KIRKLEES METROPOLITAN COUNCIL INVESTMENT & REGENERATION SERVICE

DELEGATED DECISION TO DETERMINE PLANNING APPLICATIONS

Reference No:	2023/62/92825/W
Site Address:	156, Northgate, Almondbury, Huddersfield, HD5 8US
Description:	Erection of rear extension (within a Conservation Area)
Recommending Officer:	Tom Hunt

Officer Report

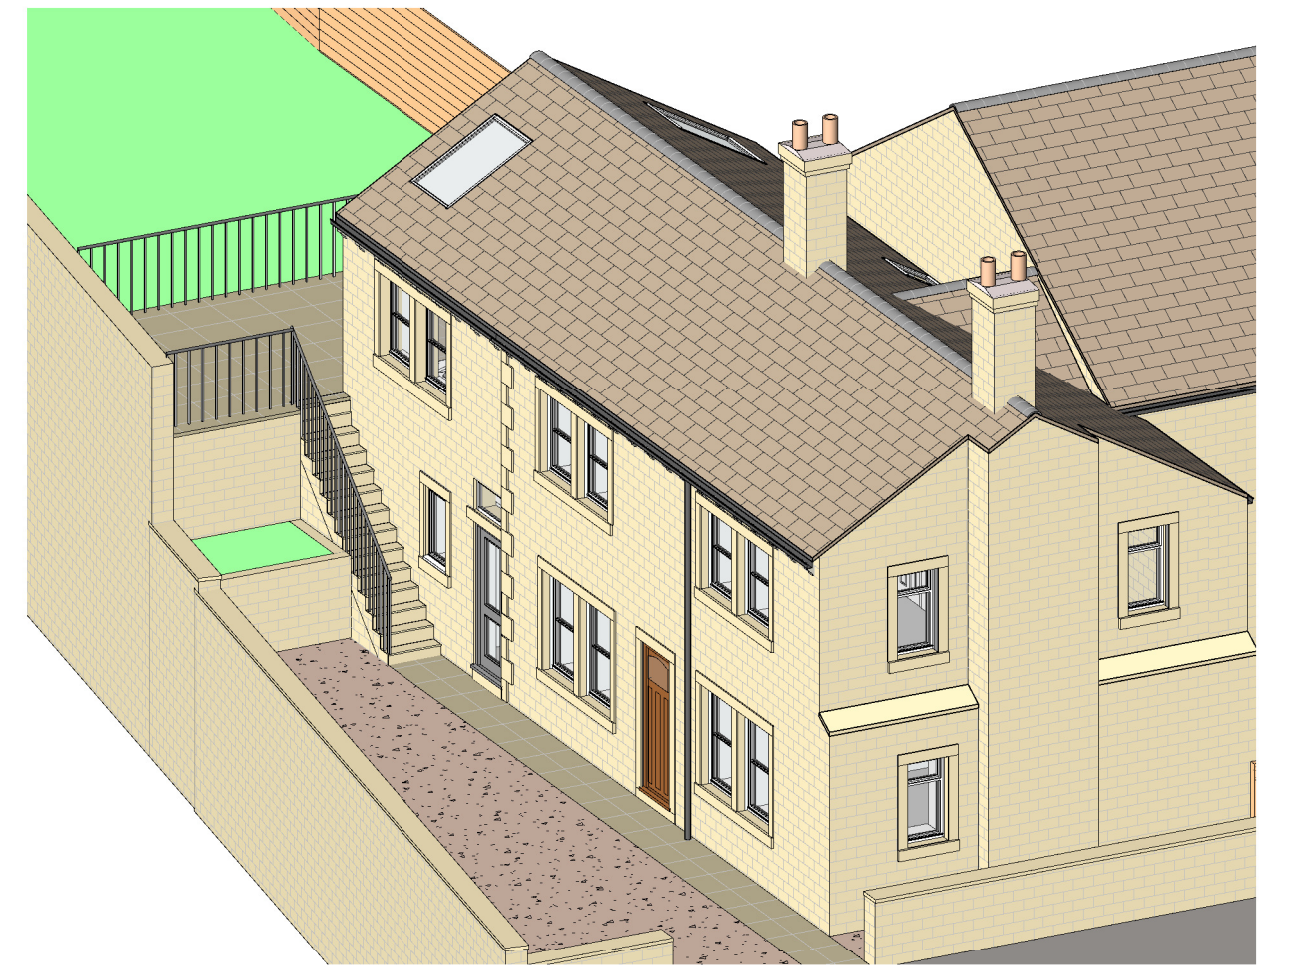
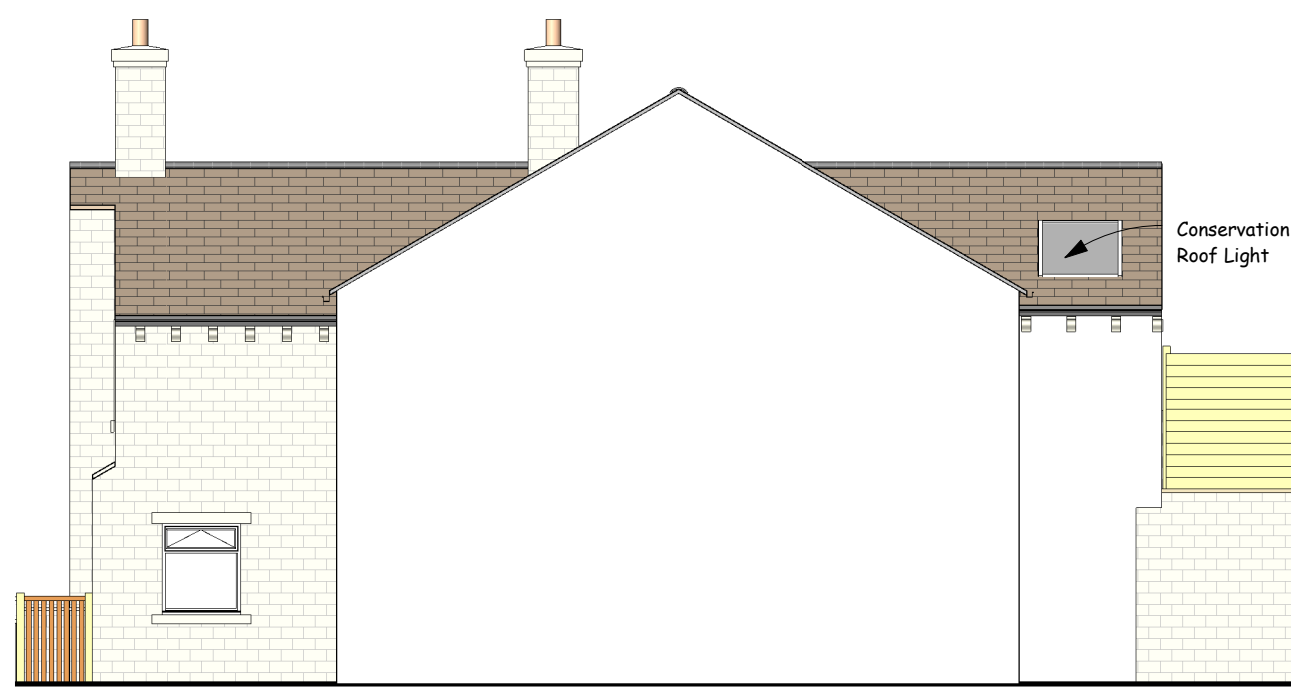
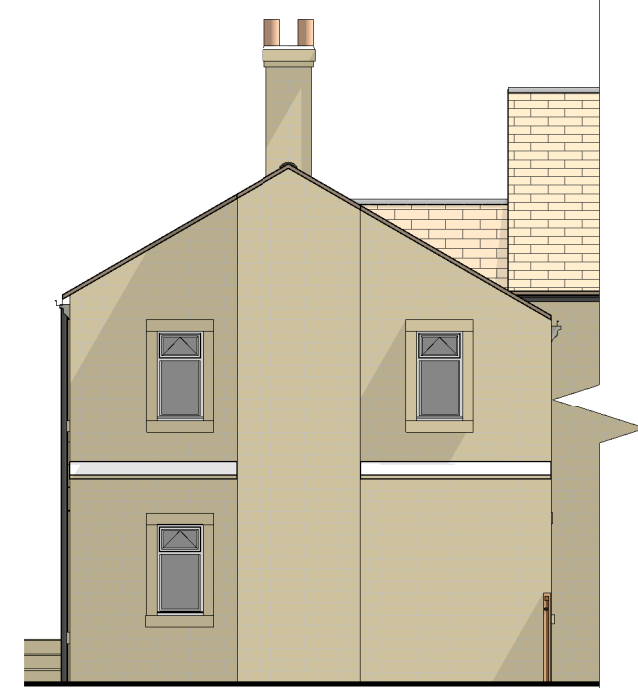
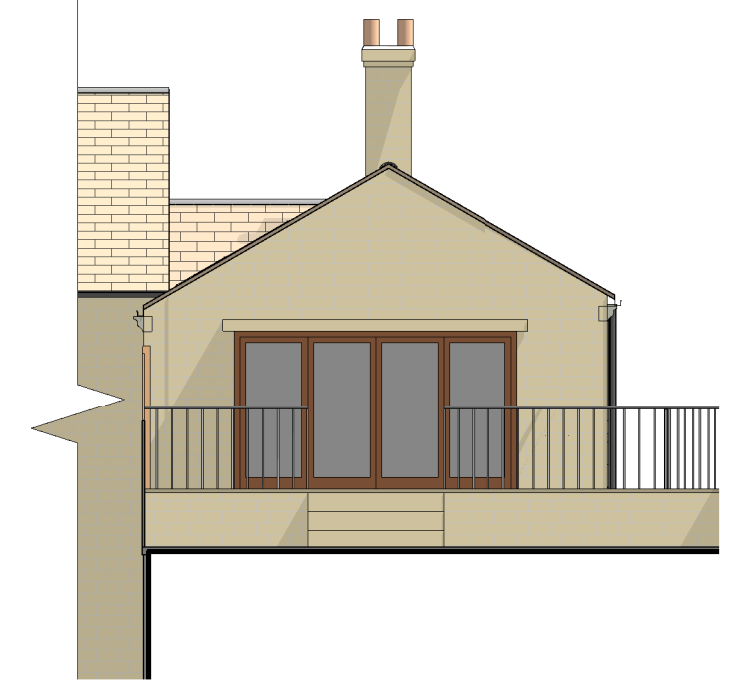
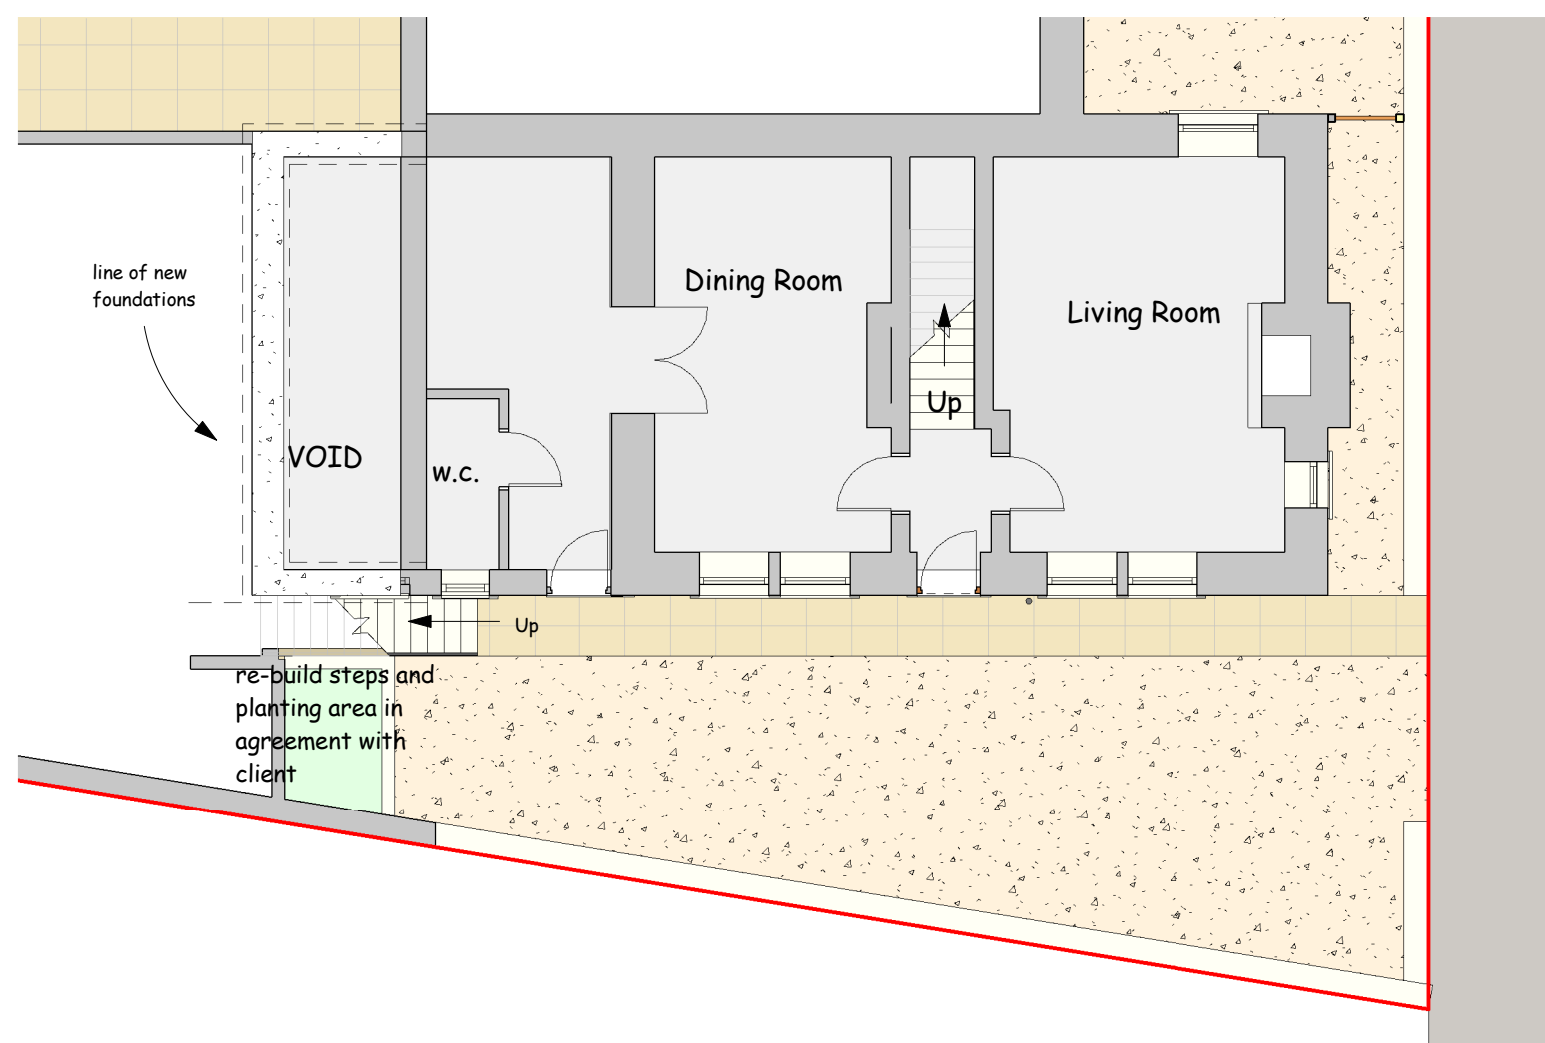
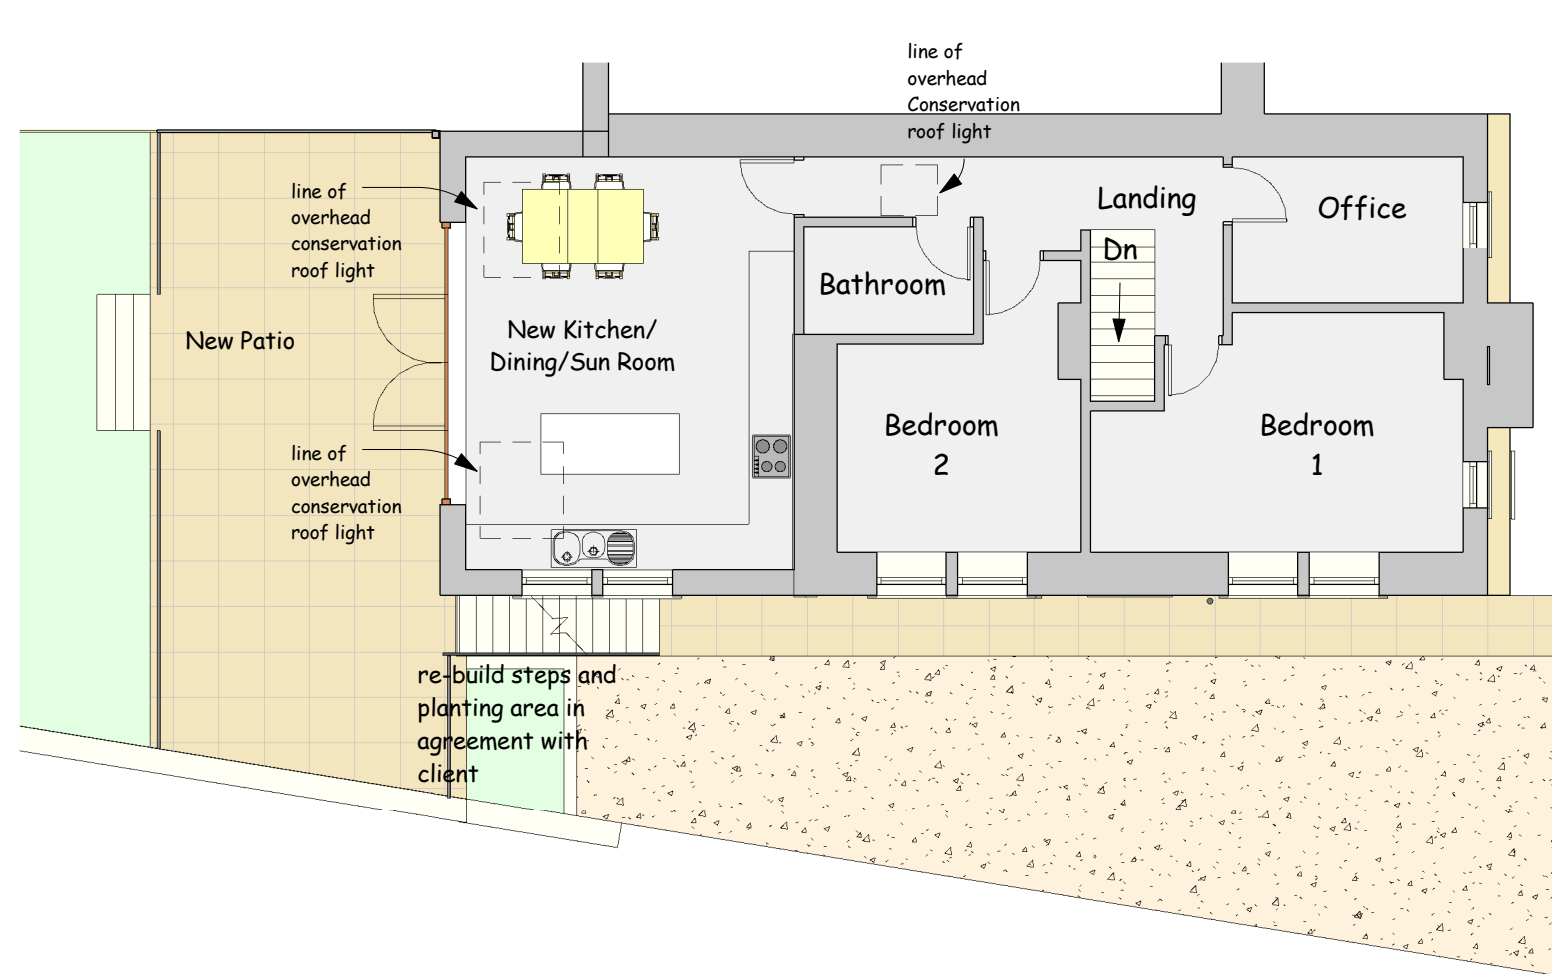
6. The 1.8m high privacy screen on the northwest boundary of the raised patio to the rear of the annex, as shown on the hereby approved 'Proposed Floor, Elevation and 3D View Plans. Drawing no. 2319-02. Revision: A', shall be constructed from solid timber and completed before this raised terrace area is first brought into use. The timber privacy screen shall thereafter be retained in accordance with the approved plans.
